RE: **Andalucia Phase 2 – 6500 Coors NW**
Grading Plan
Engineer's Stamp Date 5/3/17
Hydrology File: E12D015D

Based upon the information provided in the submittal received on 5/5/17 the above-referenced Grading Plan is not approved for Building Permit. The below items must be addressed prior to approval:

Erosion Sediment Control Plan

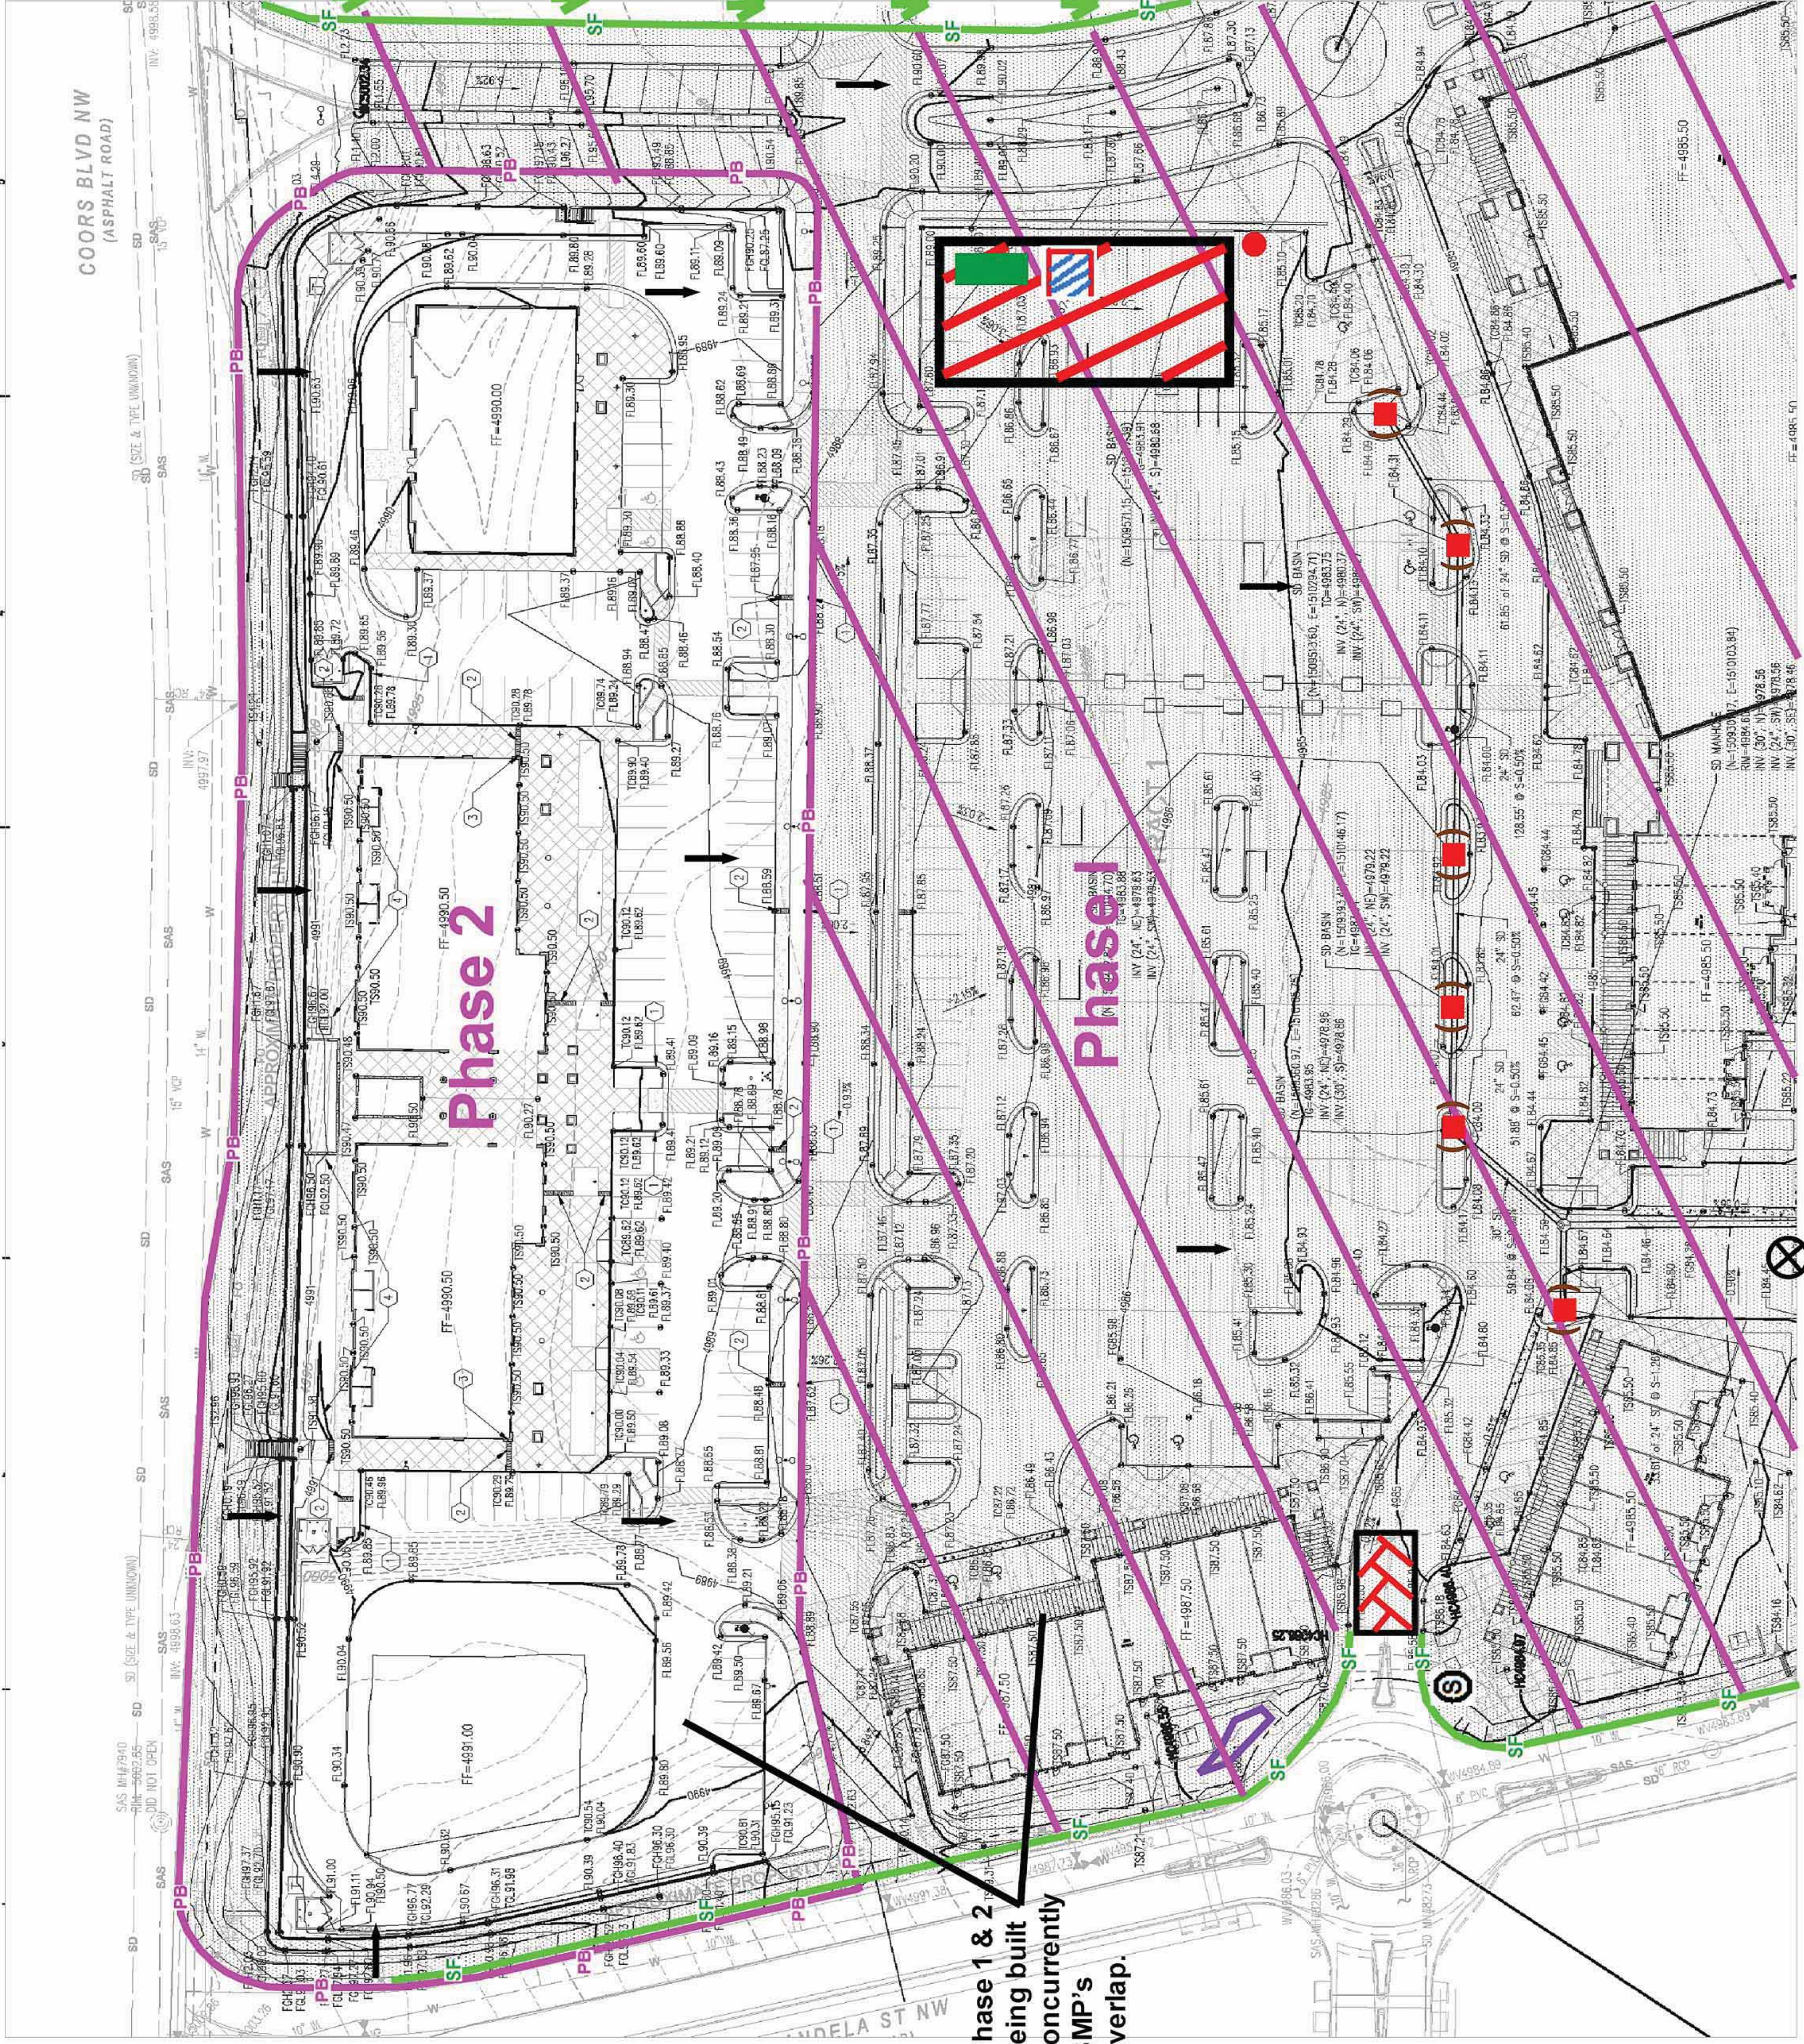
1. This project will require an ESC Plan to be submitted to the storm water quality engineer, Curtis Cherne, PE, prior to Building Permit Approval. The Phase 1 ESC Plan is not applicable for Phase 2 as it uses Phase 2's project area as staging grounds.
2. The restaurants/retailers need to be labeled as such. The dumpsters for the restaurants need to be contained, drained through a grease trap, and into the sanitary sewer.
